Re: Objection to MP08_0244 MOD 1 Modification Request for Mixed Used Development at 23-37 Lindfield Avenue and 11 Havilah Lane, Lindfield

As a resident of Lindfield, I/we wish to lodge an objection against the proposed Modification of the subject development based on the following grounds:

1 JUNE 21 -9AM
1:500

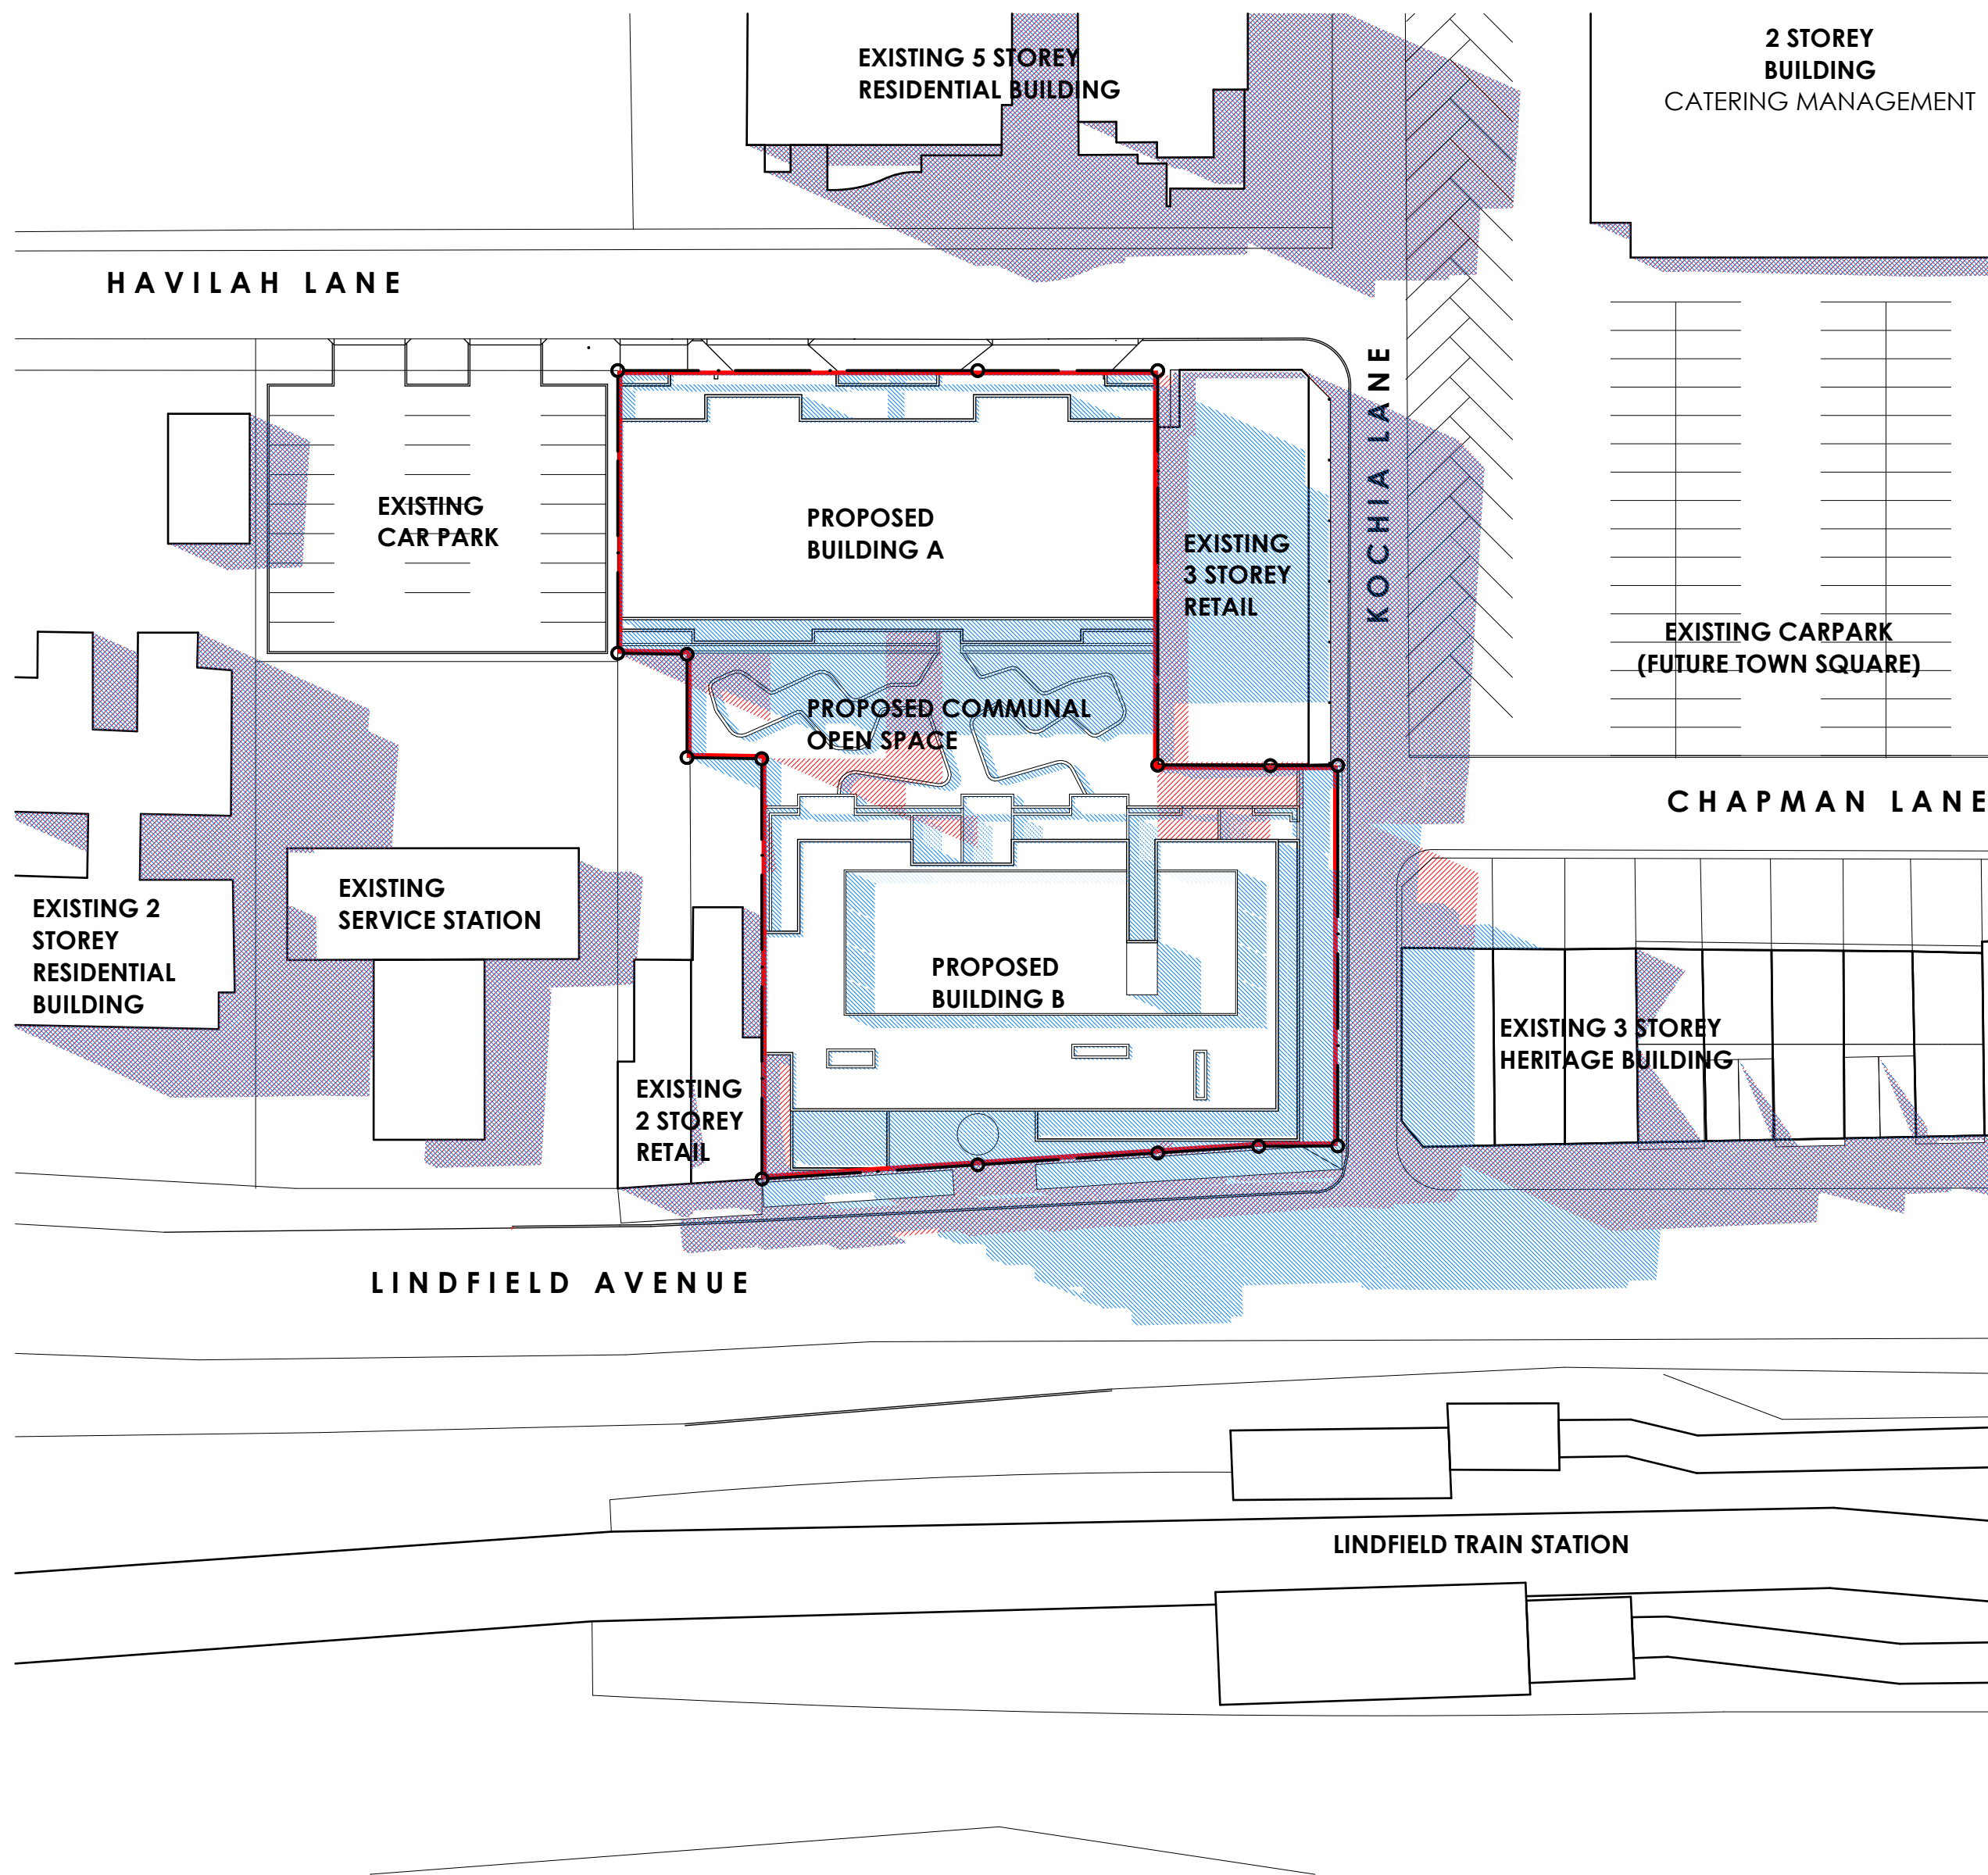
- The additional storeys create new adverse shadowing: a) for residents in the Havilah Lane apartments, particularly after 3pm b) for the popular outdoor café and central Lindfield hub area at 12 Tryon Road in afternoons, particularly in winter and c) for all commuters on the city bound Lindfield rail platform, instead of 50% of the year as approved, it will now be in shadow in the mornings 75% of the year
